DEPARTMENT OF PLANNING

SUBJECT: BILAMBIL VILLAGE RESIDENTIAL SUBDIVISION 08_0034 MOD 1

To determine a modification request for the Bilambil Village Residential Subdivision.

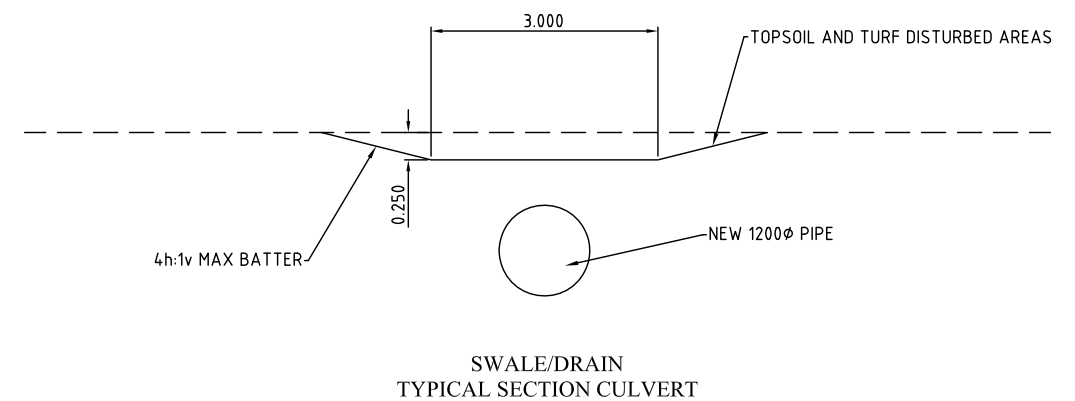
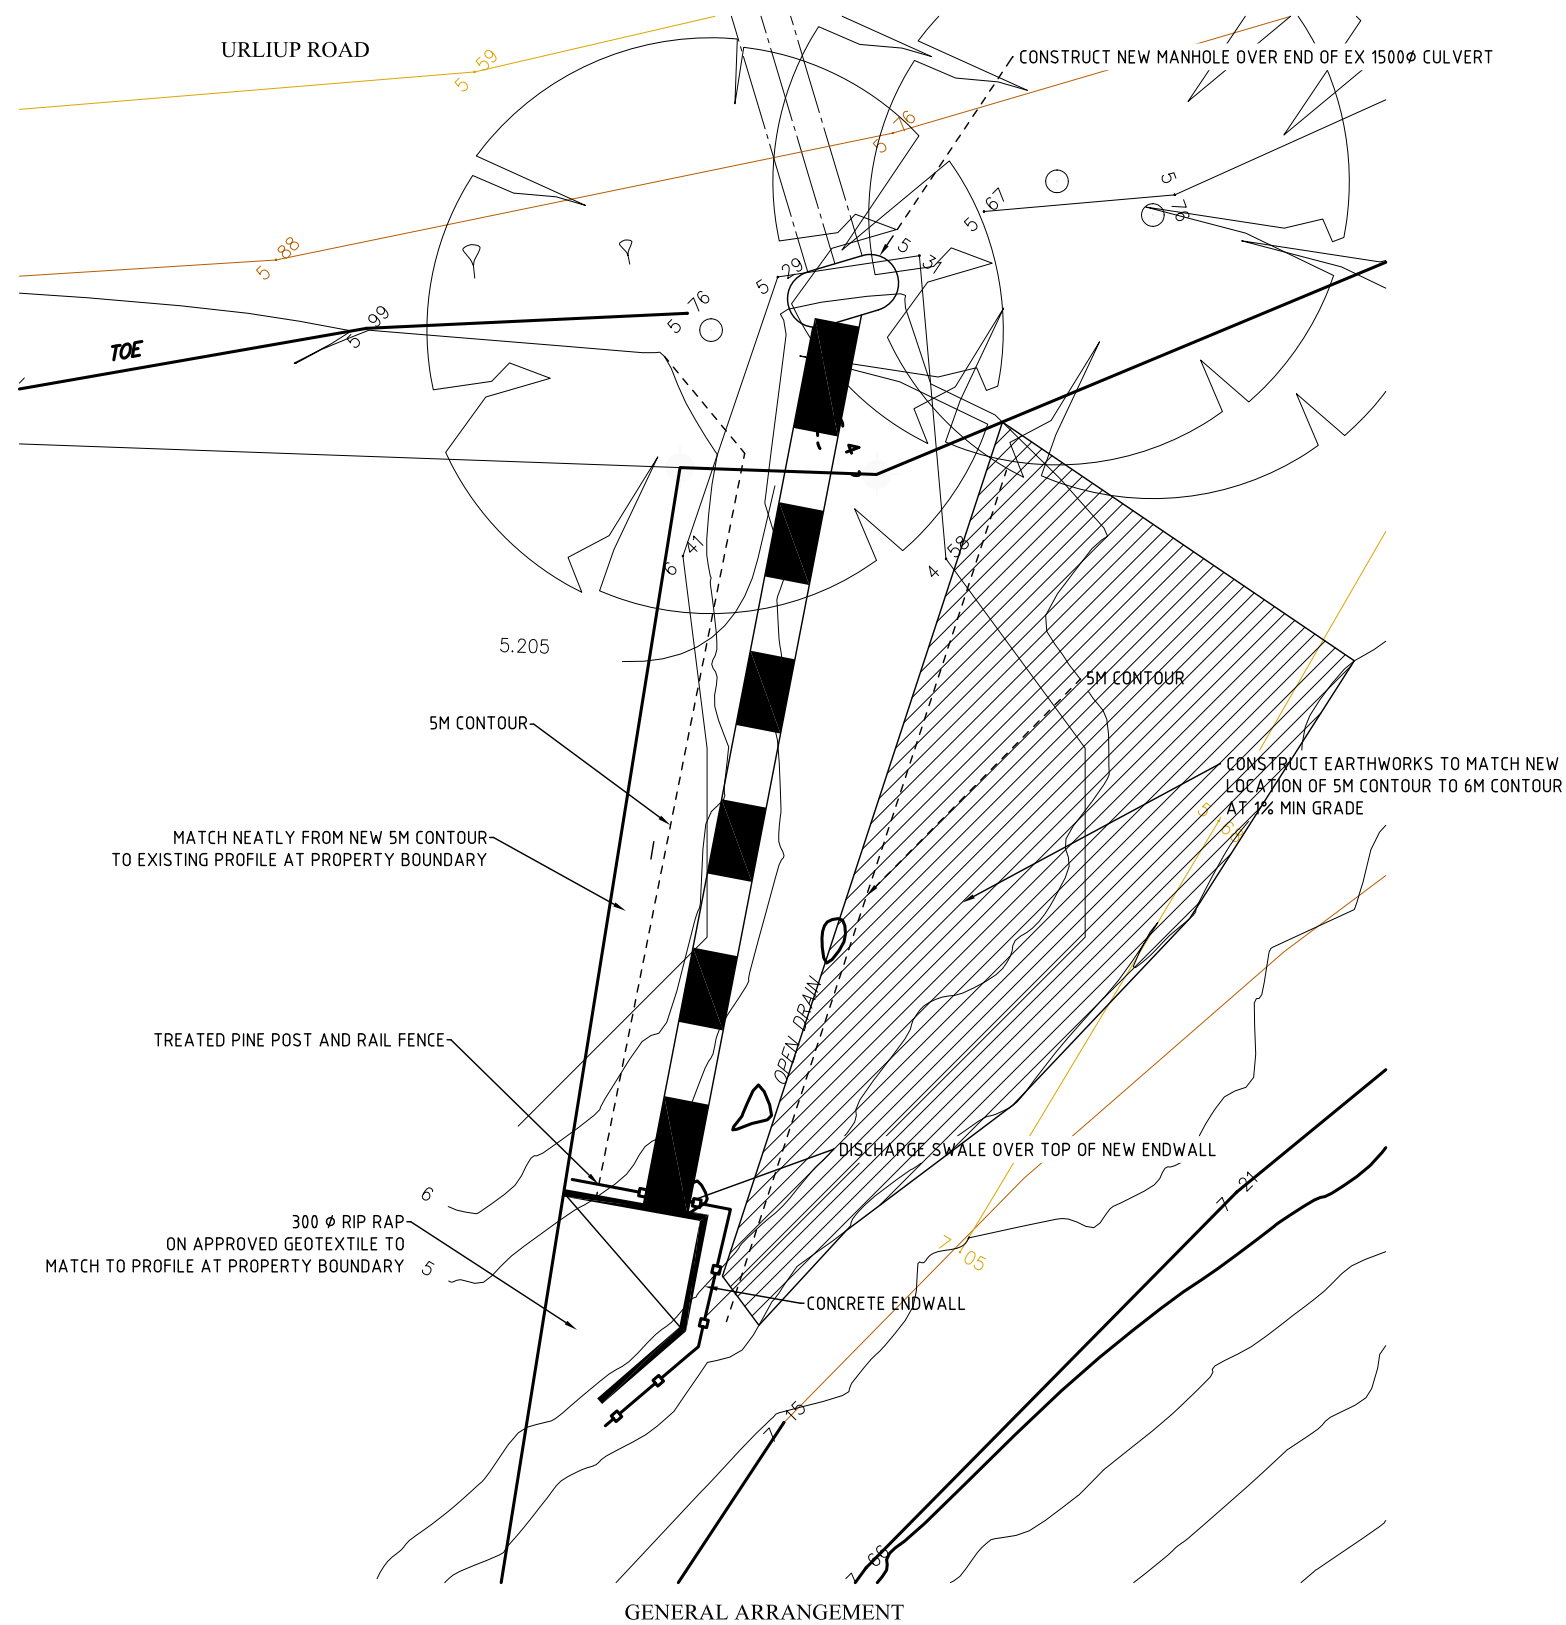
As part of this modification request, the proponent seeks to replace the open drain immediately behind Lots 1, 2 and 3 with a 1200mm diameter pipe that connects to the existing pipe draining beneath Urliup Road. The 14.5m pipe will follow the same channel as the existing open drain and discharge to the same point as it does now over flow dissipating rock rip-rap. Filling over the top of the pipe will require minor earthworks that will be married into existing levels at the neighbouring property. There are no additional impacts on flow rates and the neighbouring property than that already consented to.

On this basis the Department has no objections to the proponent filling the open drain and recognises that it provides greater amenity and usable space for Lots 1, 2 and 3. Condition A3 of the approval will be modified by the addition of the appropriate engineering drawing to allow this.

Ref. No.	Date	Drawing No./Size	Rev.
T15337	31/07/08	17154 D	L

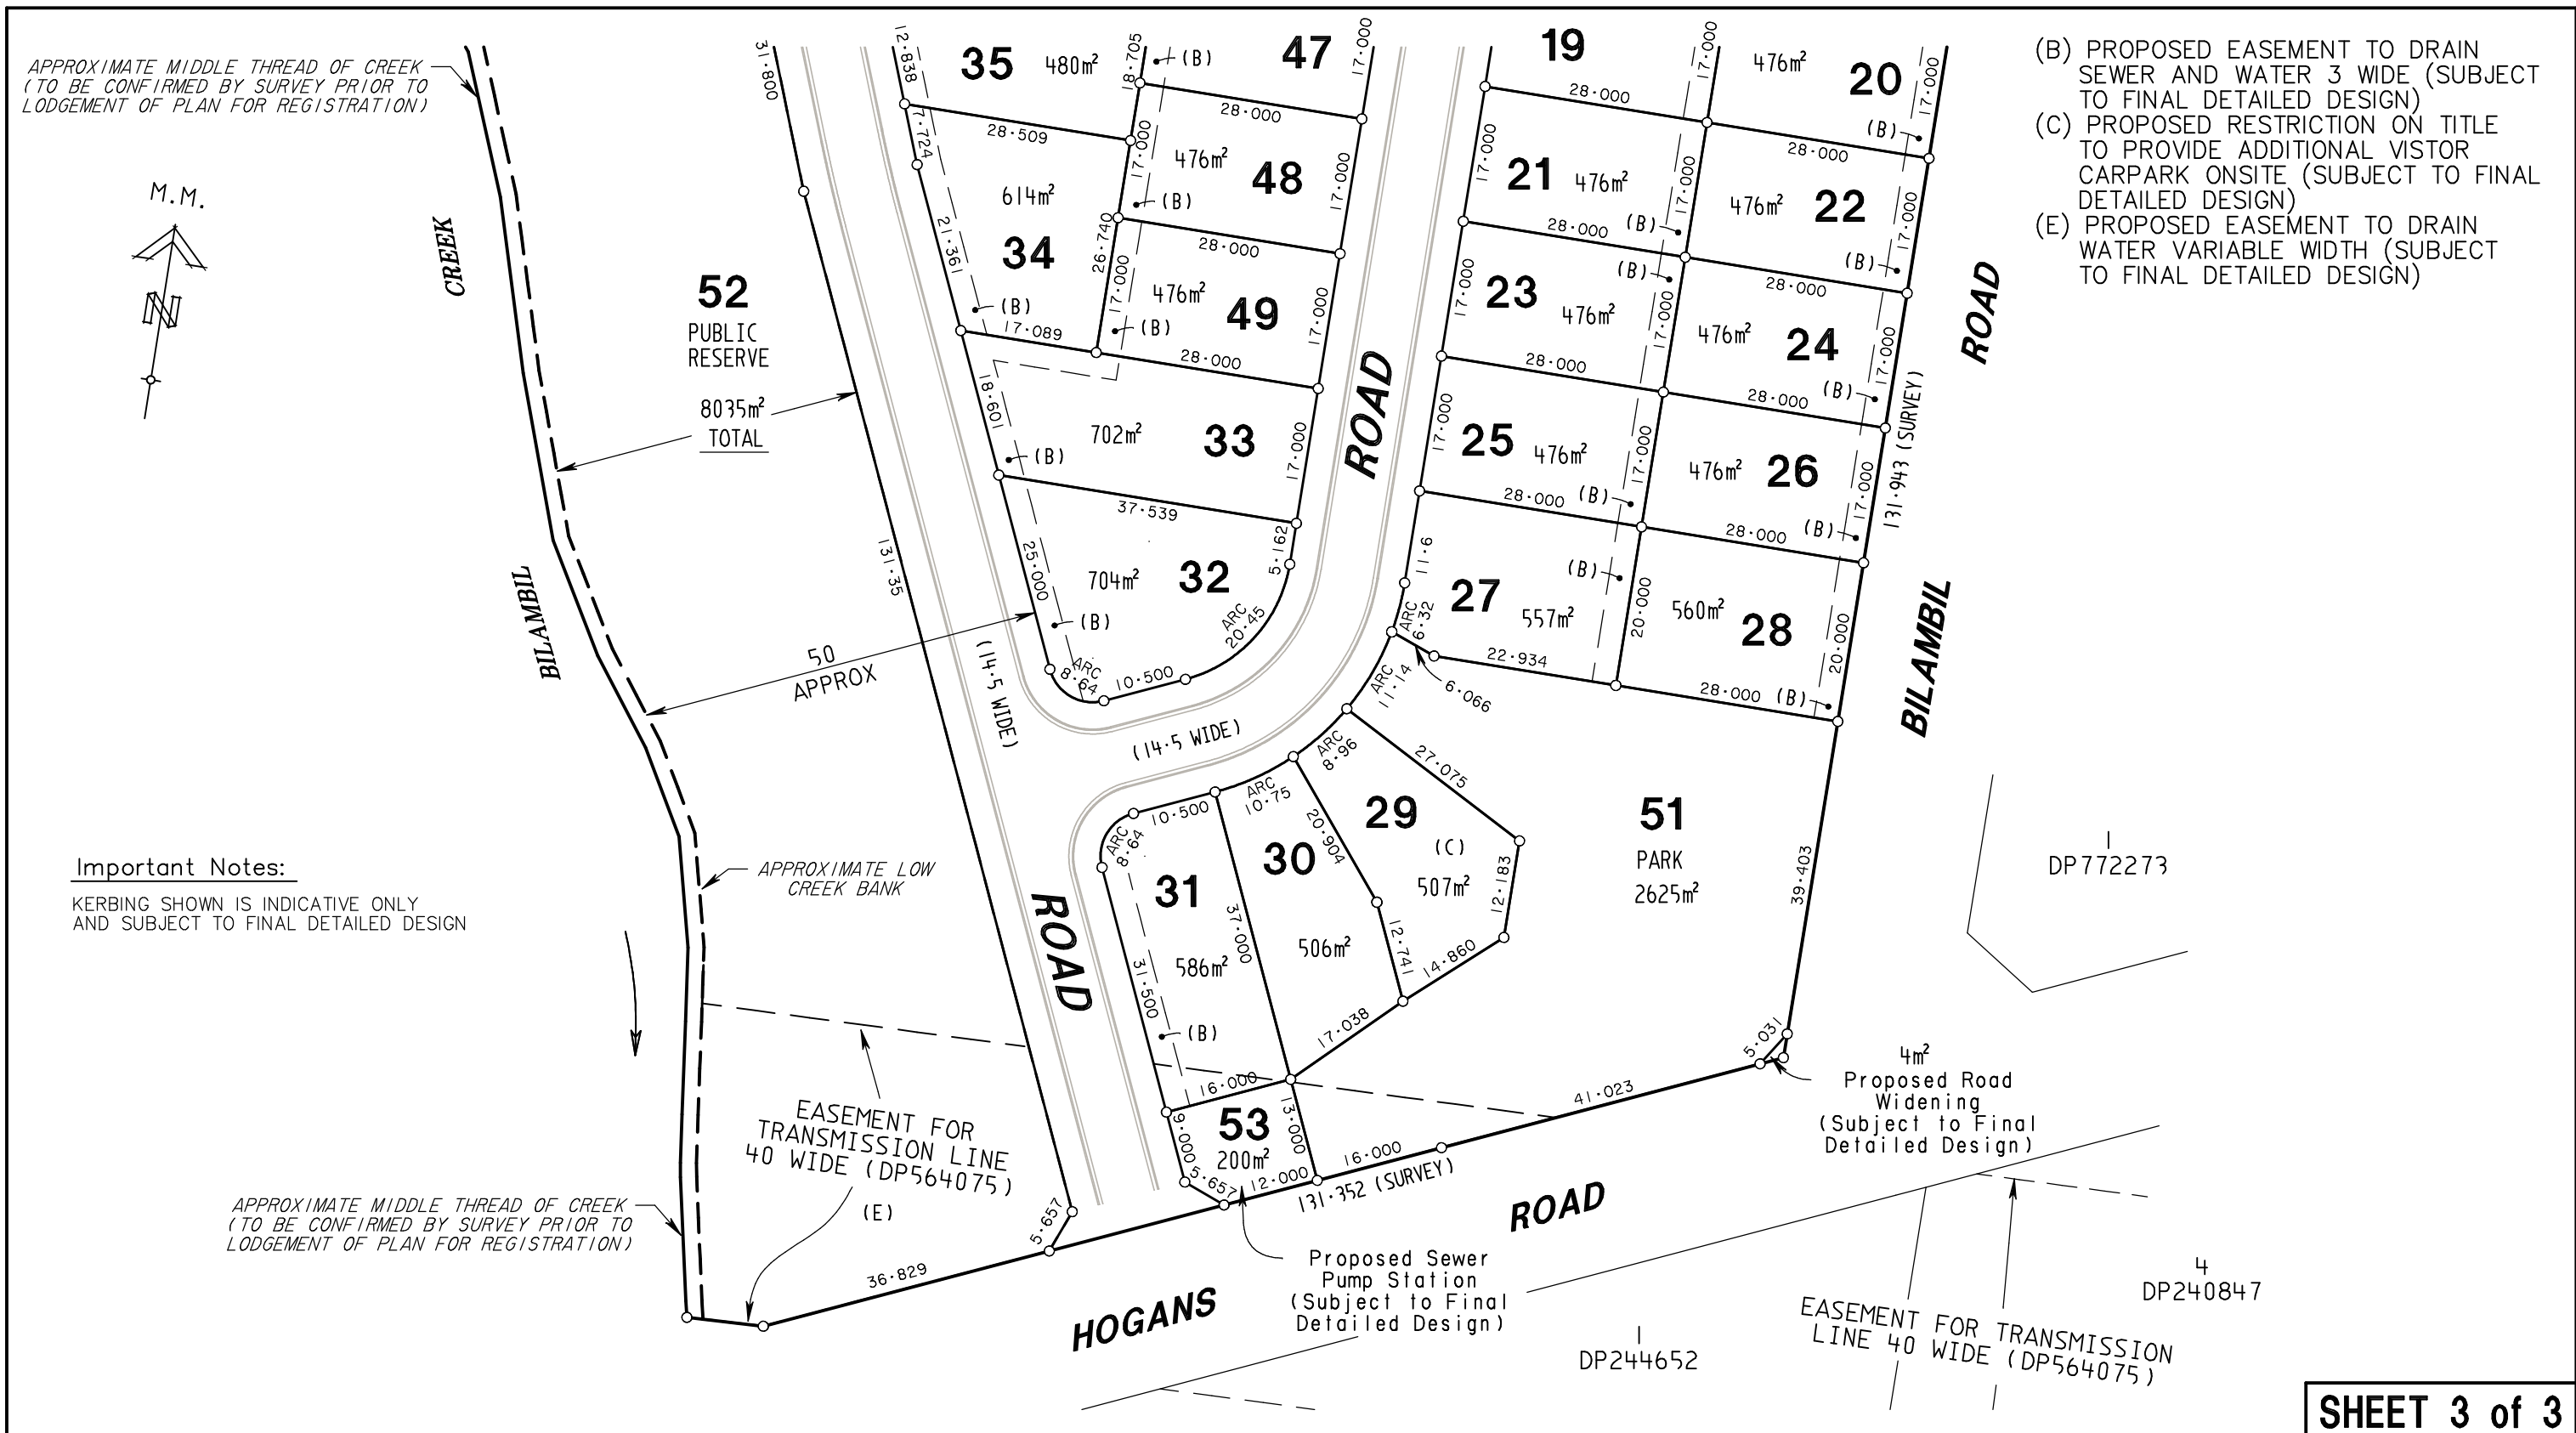
The final plan submitted (11 October 2010) shows a reduced riparian area to Bilambil Creek (in both width and area). As detailed above, the 35m nominal width of the riparian area is already an agreed compromise and further reductions to this are unacceptable. Furthermore, to achieve a suitable building envelope on Lot 1 with a 15m APZ provided for, the proponent has reduced the lot sizes of Lots 2, 3, 4, 5 and 6 thereby compromising the agreed lower density lots fronting Uriup Rd.

Although variable, in general the nominal 35m buffer to Bilambil Creek is achieved along the entire margin of Lot 52 with the approved plan of subdivision. The variability arises from natural erosion and accretion cycles of the banks of Bilambil Creek. As Table 1 shows, the nominal 35m buffer is already reduced in the vicinity of Lot 1.

Although detailed survey plans are required to be approved prior to the issue of a subdivision certificate for the development, the precautionary principle must be applied and the originally approved condition A2(1) retained. Therefore any further reduction in environmental (riparian) buffer width in this vicinity is not supported.

Therefore for the reasons detailed above, the Department is not able to support the proponent's modification request to reinstate Lot 1. Furthermore, conditions will be amended to ensure a 15m wide APZ is provided for on the Lot created by the amalgamation of Lots 1 and 2.
